Our Ref: LU/48/17/L

22nd February 2017

Application for Listed Building Consent

Development Application for Listed Building Consent for new vehicular access with lych gate and sliding gates
Location Toddington House Toddington Lane Littlehampton

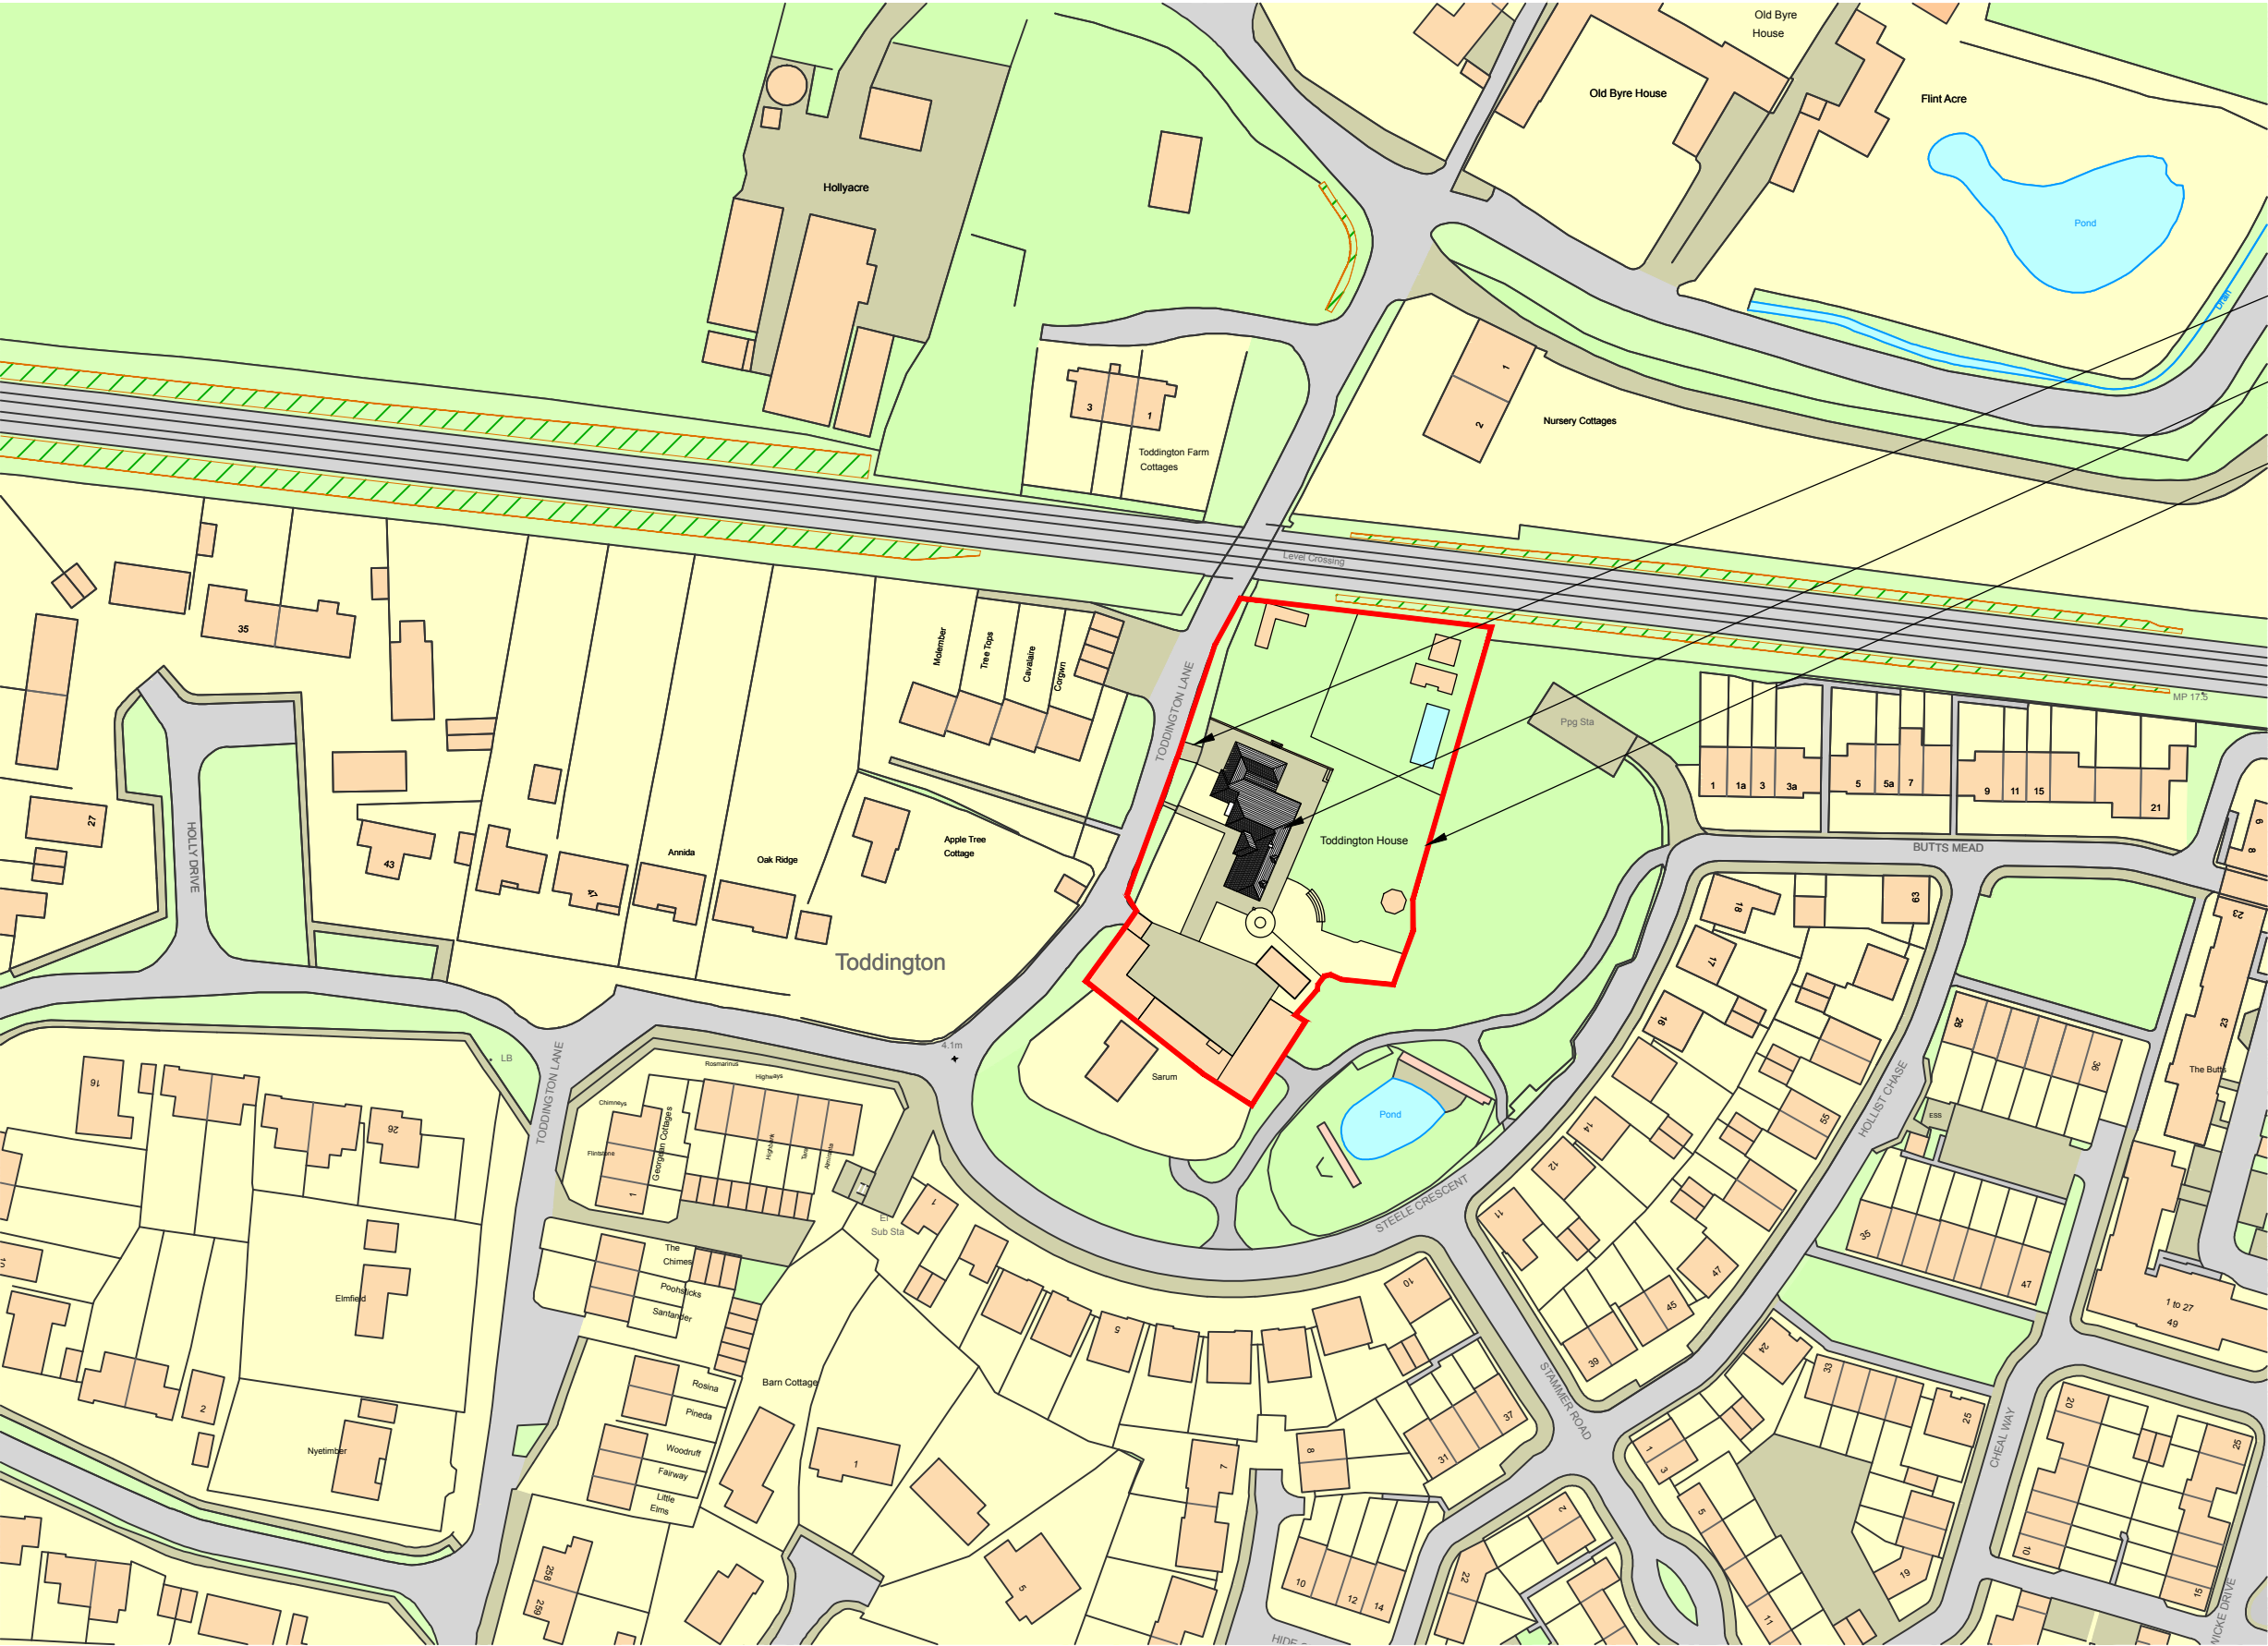
As you are applying to change the crossover please confirm whether works will be done to the pavement. If so, this area needs to be within the red outline on the location plan and would also be useful on the site plans
